From: Laura Gibbons <Laura.Gibbons@arun.gov.uk>
Sent: 05 October 2021 15:08
To: Planning.Responses <Planning.Responses@arun.gov.uk>
Cc: David Easton <David.Easton@arun.gov.uk>
Subject: RE: Planning Consultation on: Y/140/21/DOC

We have the following comments on conditions 9 and 10.

Site Address: Land at Bilsham Road Yapton

Description of Works: Approval of details reserved by condition imposed under Y/91/17/OUT relating to conditions 9-surface water drainage scheme, 10-details of maintenance & management of surface water drainage system & 12-foul drainage system.

BILSHAM ROAD, YAPTON			
Drawing Title PRELIMINARY ENGINEERING LAYOUT. SHEET 1 OF 2			
Client BILSHAM ROAD DEVELOPMENT LLP			
Scale 1:500 @A0	Date FEB 20	Designed NA	
Drawn LS	Checked JH	Approved GG	
Job No 19-326	Drawing No 19-326/009	Rev N

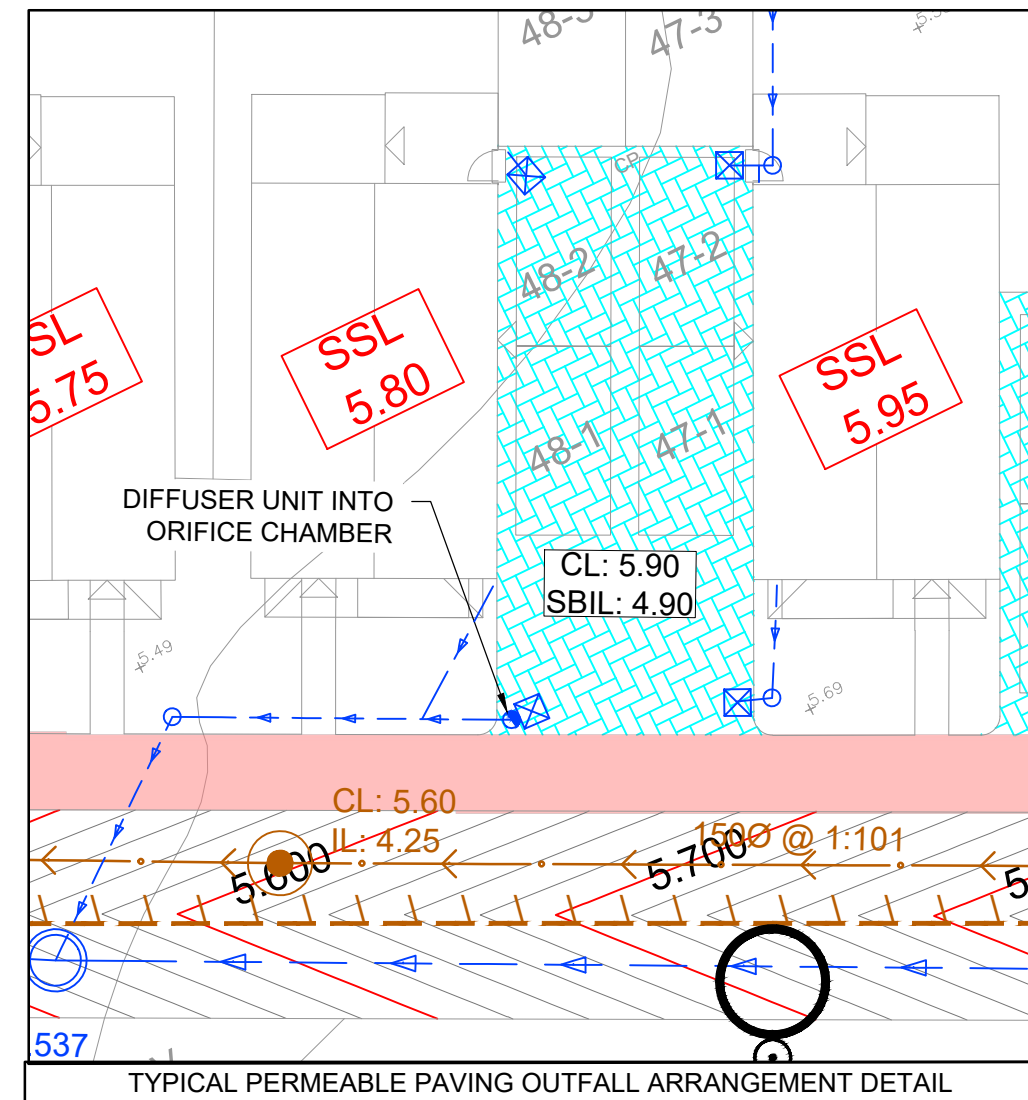
1. Catchpits must be clearly identified on layouts.
2. Finish and formation levels of permeable paving must be detailed on plan.
3. Layout plans must show connections from roads, driveways and plots to the drainage network. Diffuser blocks must be labelled with invert levels.
4. Hydrobrake unit references must be detailed on plans and construction detail drawings.
5. The invert level of the proposed connections to the culvert and watercourse must be provided, along with the invert level of these existing features at the proposed points of connection. Upstream and downstream bed levels of watercourses must also be provided on plans.

8. Calculations have some discrepancies to drawings, namely: MHs 26, 80, 98; and the attenuation tank which is calculated as being 1.5m deep, yet is 1m deep on plan.

9. Flooding is shown in calculations. Significant flooding is shown at pipe 19.000, the falls of the road are towards Bilsham Road, it is unacceptable for a development to increase flood risk elsewhere, it is also an offence to flood a highway. These incidences of flooding should be removed, and other areas of flooding reviewed and alterations made.
